CITY OF ALBUQUERQUE

Re: Taco Bell Renovations
4815 4th St NW
Request for 90-Day Temporary C.O. - Accepted
Engineer's Stamp dated: 8-26-15 (F14D071)
Certification dated: ~~NA~~ 2-16-16

C-101

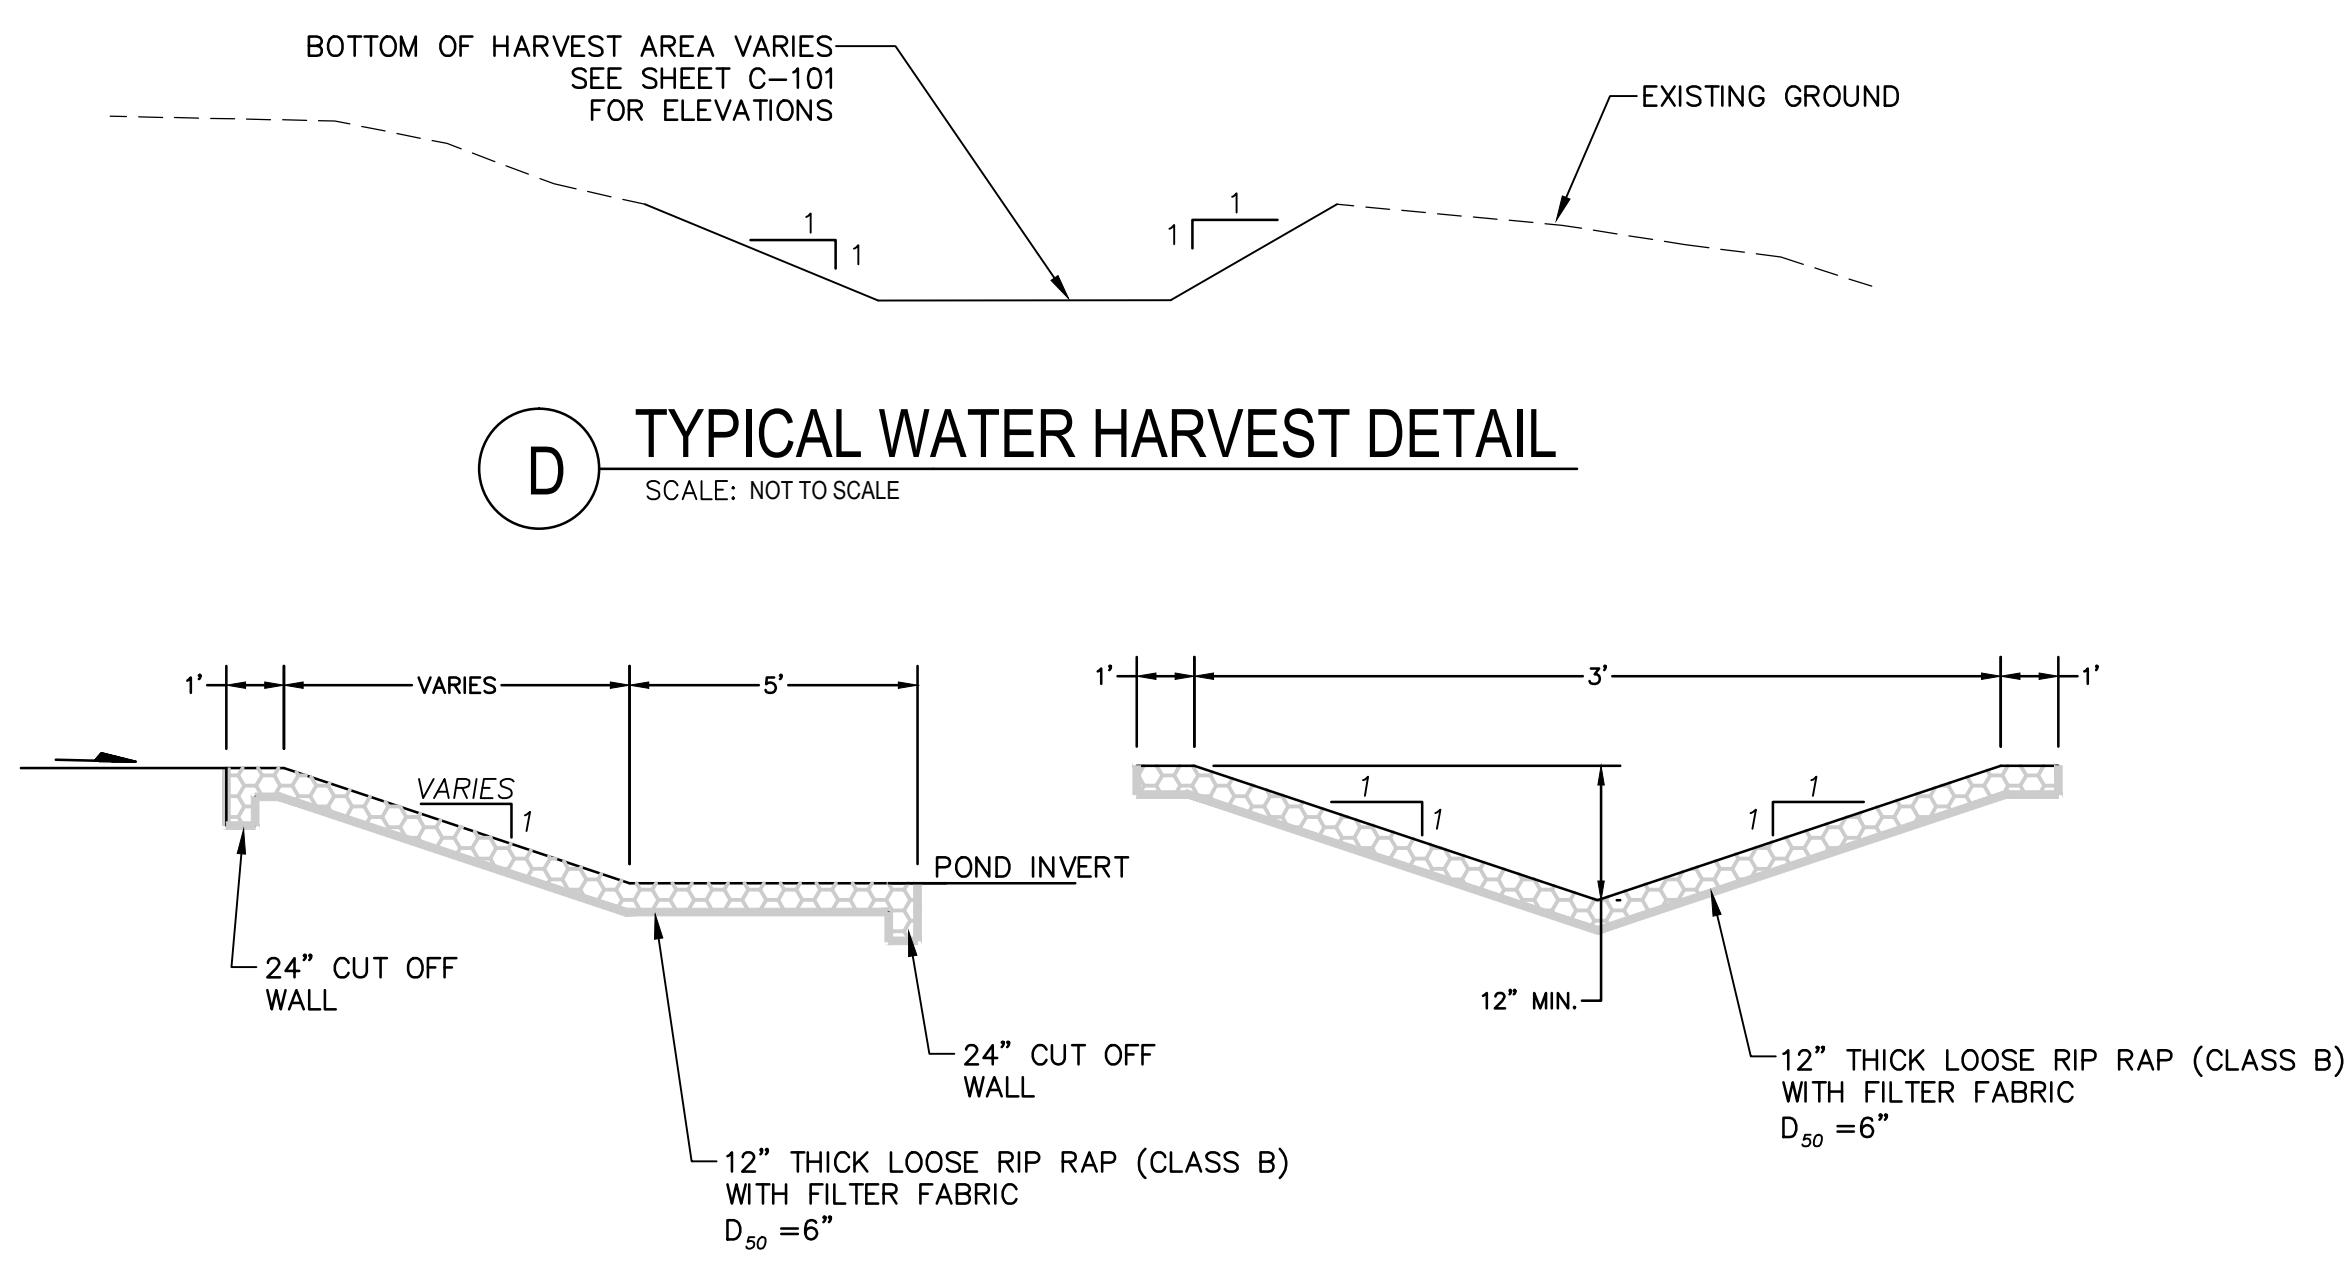
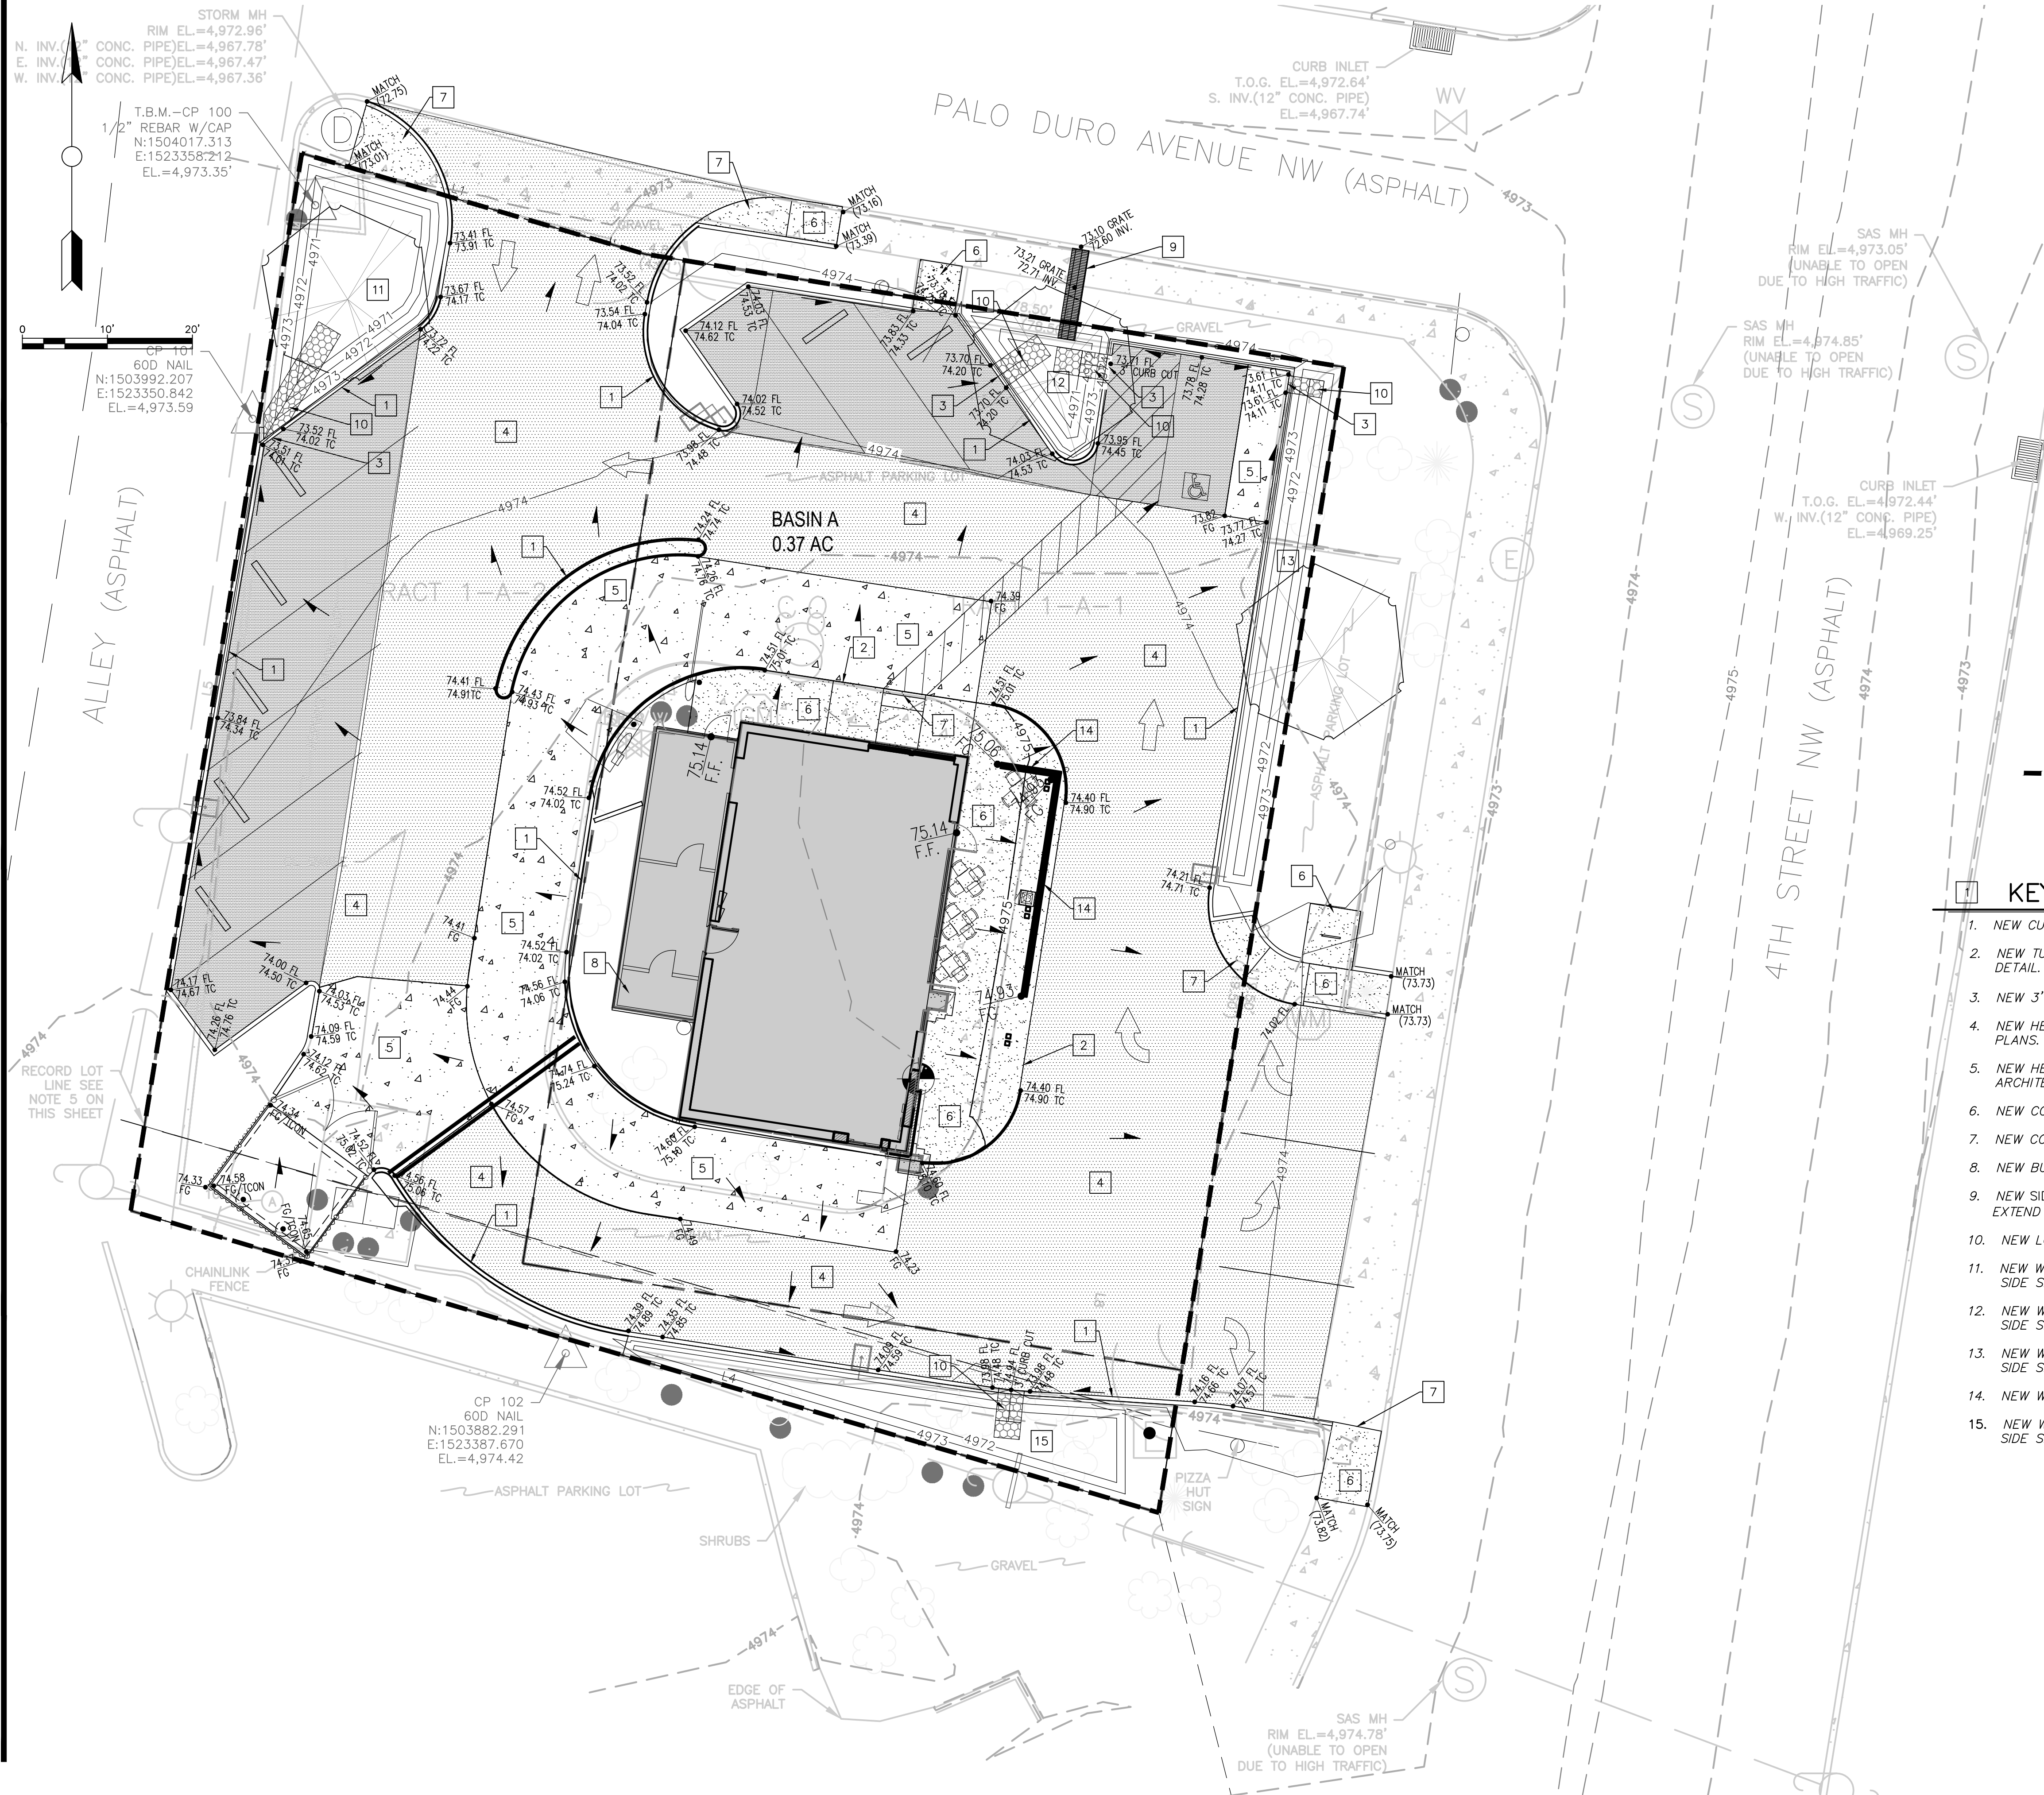
- The sidewalk culvert must be completed. Until it is complete it must remain barricaded with "Sidewalk Closed" signs on both sides starting at each entrance to the site. The bottom of water harvest on this pond needs to be approximately 3'-3" below TOC.
- The pond that diverts to the above mention culvert needs to be graded to flow into the culvert.
- The bottom of water harvest on the NW corner needs to be approximately 3'-3" below TOC.
- The 3' curb cut is missing from this water harvest area.
- The bottom of water harvest on the SE corner needs to be approximately 2'-3" below TOC.
- The bottom of water harvest on the east side needs to be approximately 2'3" below TOC.
